Your Ref: OWPC18348
Our Ref: FG/88/18/HH
Please ask for:
Mrs A Gardner

Detached garage to front
59 Little Paddocks Ferring

Thank you for your internet comments made on 22nd May 2018 which has been recorded as **'an objection'** with the comments as follows:

PROPOSED DETACHED
GARAGE SITE PLAN AND
PROPOSED ELEVATIONS

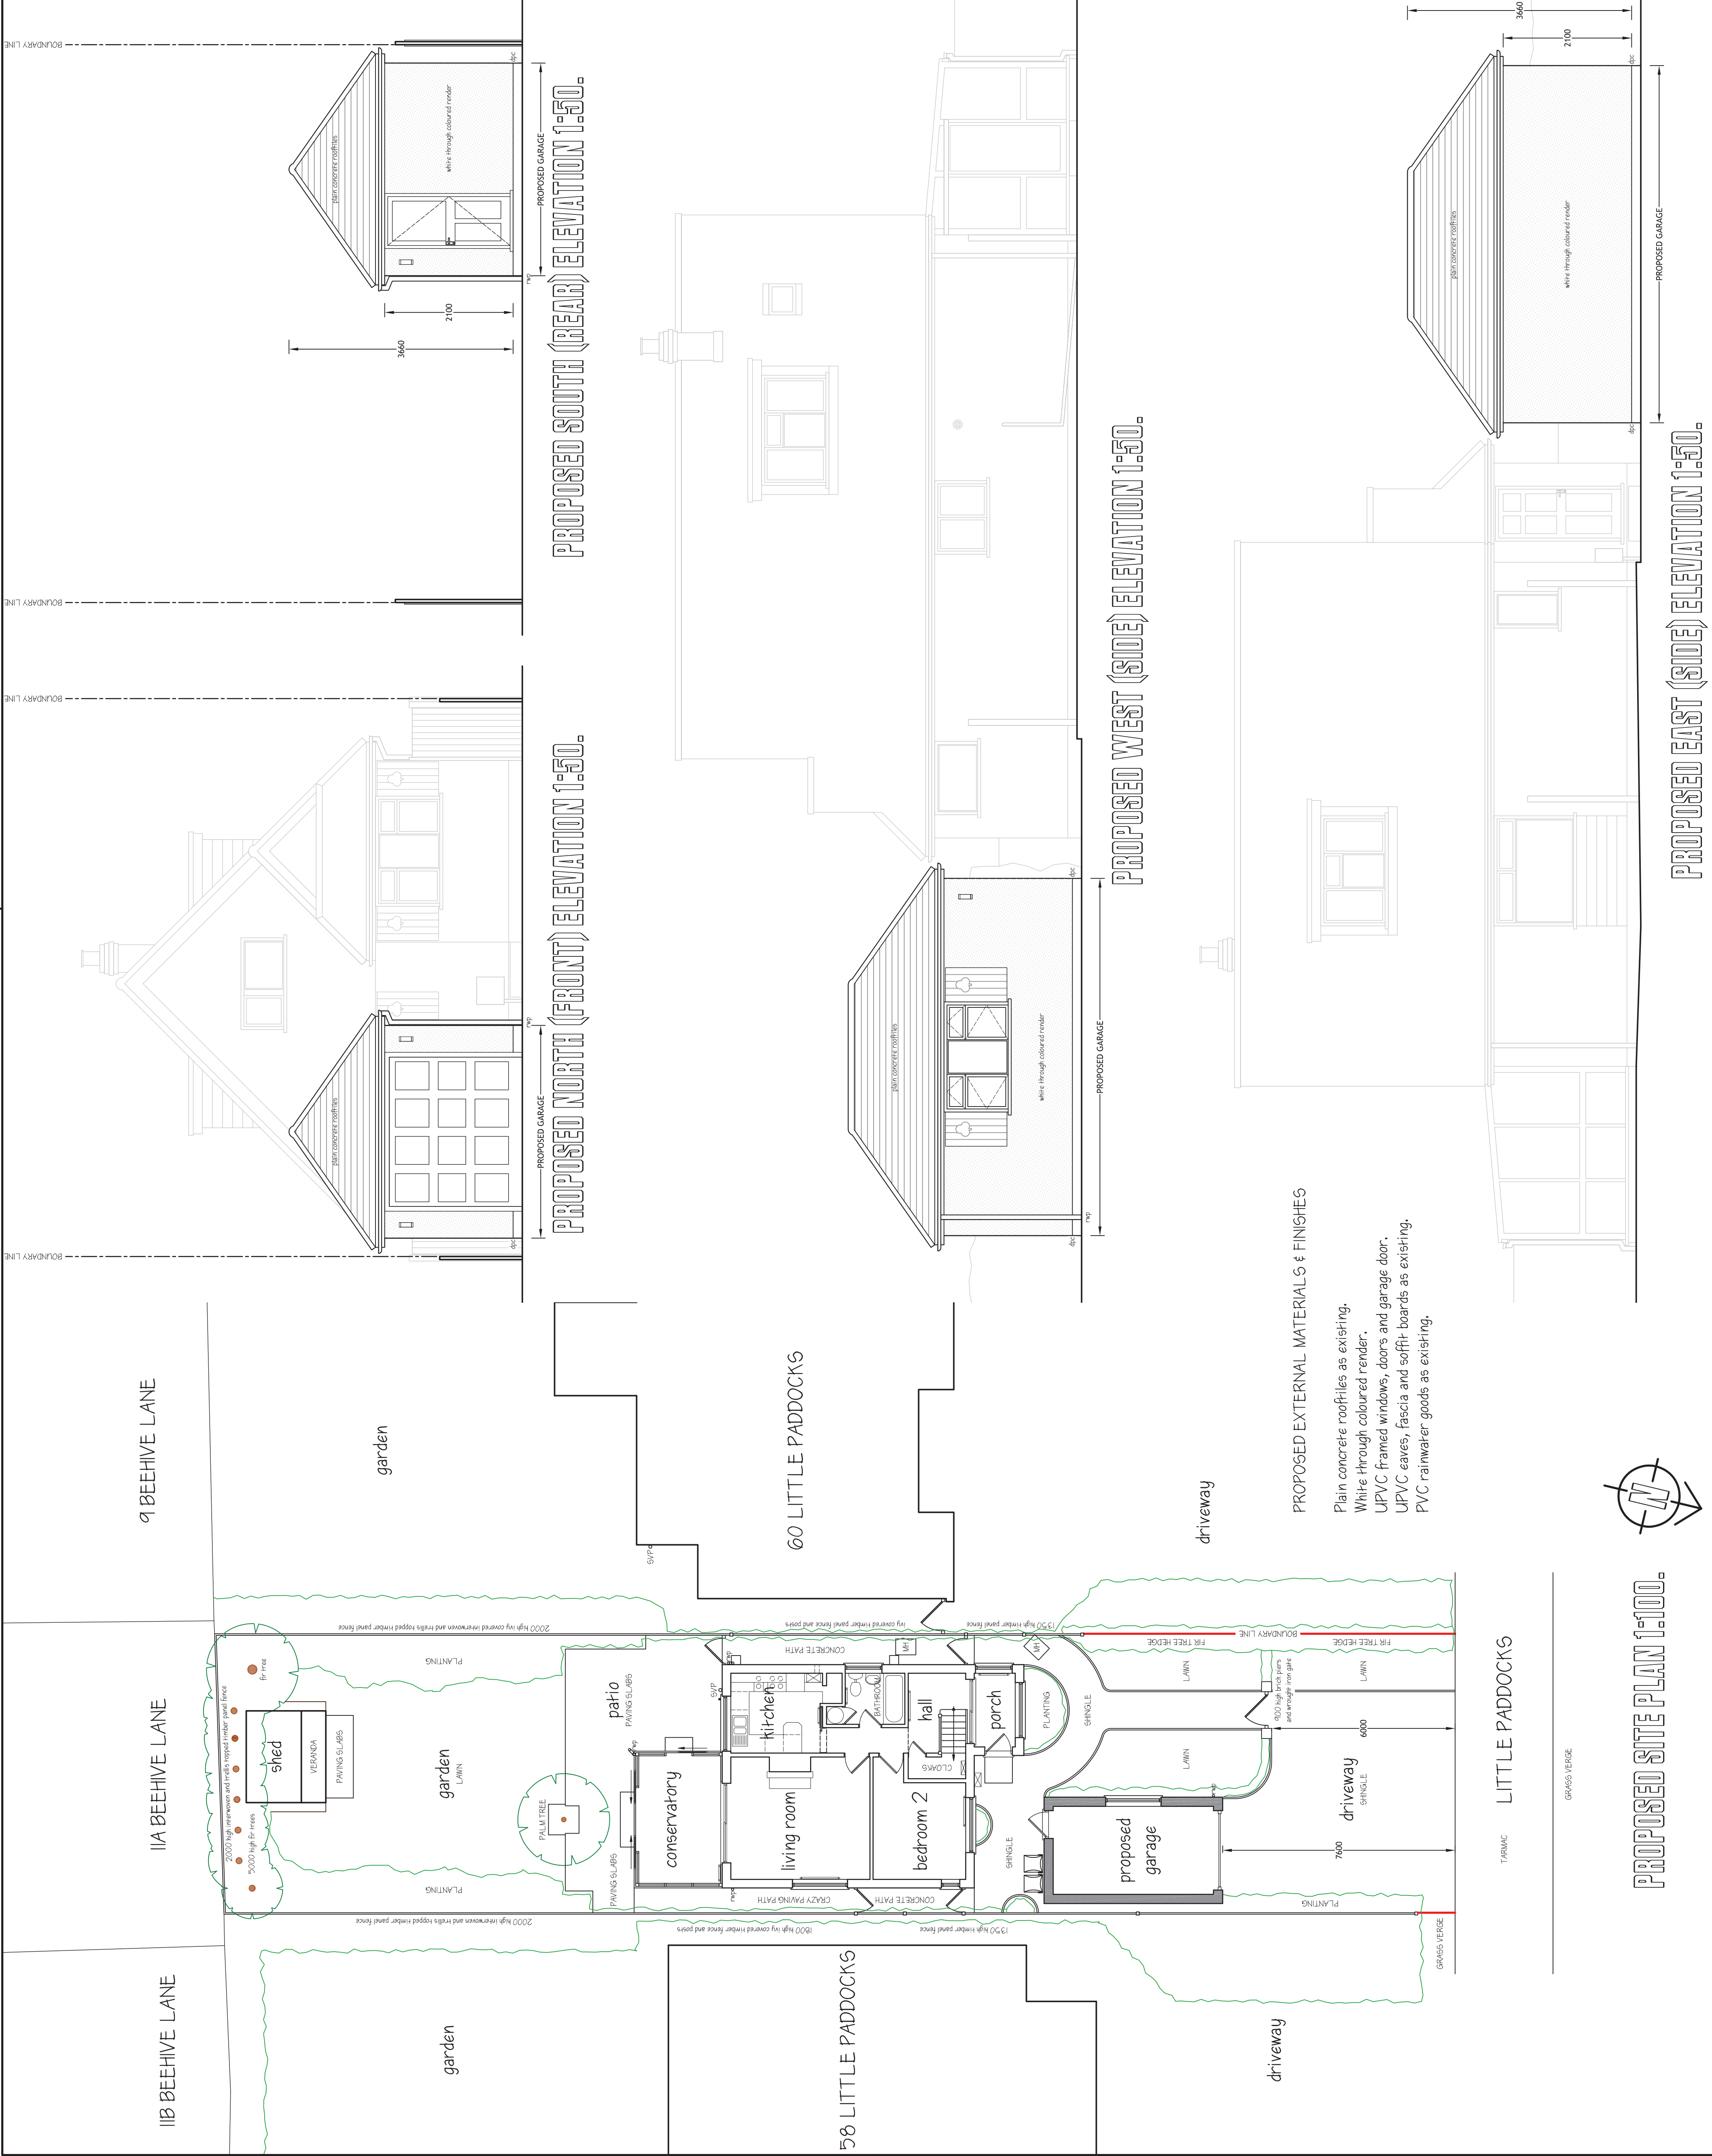
Ferring Parish Council objects to planning application FG/88/18/HH on the grounds that the proposed garage to the front of the property is out of keeping with the neighbouring properties and it will be detrimental to the character and street scene.
